DECISION DELEGATED TO DEVELOPMENT MANAGER

Application No: H23-0421-20 **Applicant:** Mr A Robinson
Proposal: Proposed flat roof single-storey rear extension with roof lantern
Location: Pink Cottage Drove Road Shepeau Stow
Terminal Date: 27th August 2020

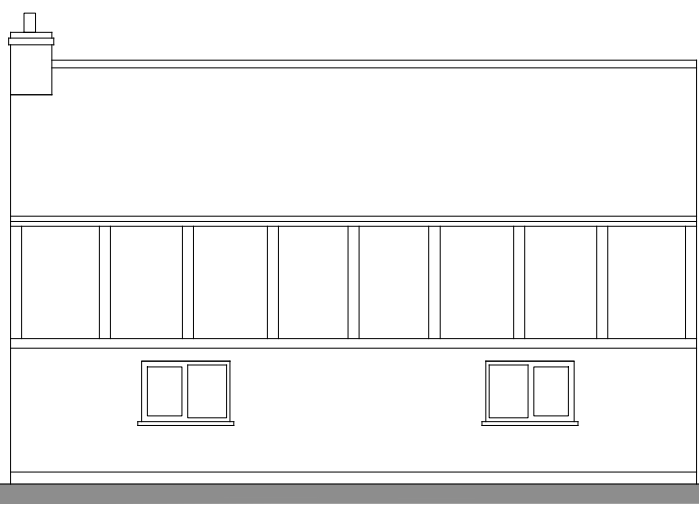
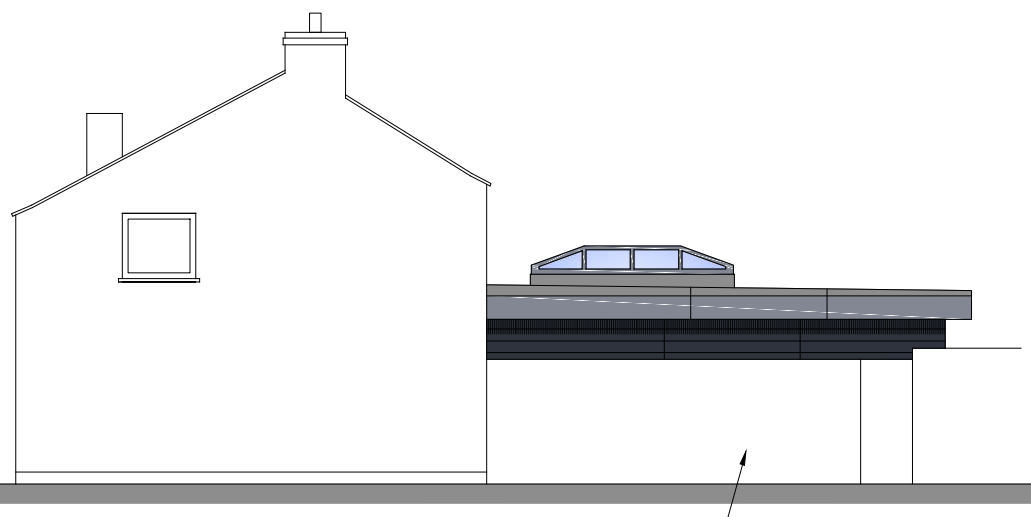
- The proposed external materials appear very industrial and will harm the traditional Fenland cottage appearance.
- Recommendation of adding a condition to the permission to ensure the proposed materials are similar to the current appearance of the building.

The external walls of the extension will be coated with horizontal black timber cladding. The openings and rainwater goods will be Anthracite grey and the roof will have a single ply membrane finish in lead colour.

The development will deliver a contemporary appearance in contrast with the rural character of the host property. Dark colours will match with the dark brown Tudor features on the front elevation of the cottage and will be also sympathetic with the prevailing pink render finish of the building. Furthermore, as the proposal is for a rear extension, views from public vantage points will be minimal.

A resident representation has been made with regards to the proposed materials. However, it carries little weight in this assessment as it was misunderstood that the new materials will be applied across the entire dwelling.

Ground Floor Plan
PROPOSED 1:100

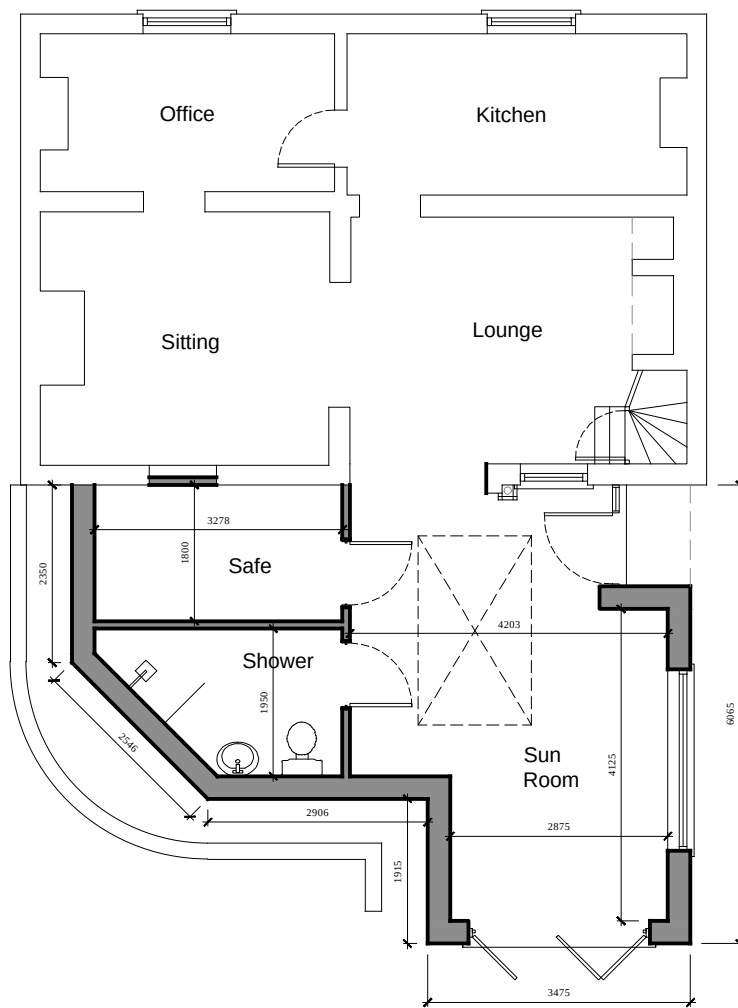
The scale and height of the proposed extension are such that the development is deemed subservient to the host property. The footprint is adapted to the layout of the brick wall that separates the rear garden with the site access running to the north-west which serves the neighbouring property Gremora.

The garden brick wall will remain. In addition to the roof lantern, bi fold doors and windows will face onto the rear garden away from the brick wall. In doing so, the position of the openings is such that it will enhance the enjoyment of daylight for the users of the proposed sun room.

A 6 metre separation distance is provided with the south-eastern boundary of the site. As the nature of the extension is single-storey, no overbearing effect will occur to the residents nearby. Likewise, no overlooking effect will take place onto the adjacent plots. The rear garden of the application site is appropriately fenced which obscure views.
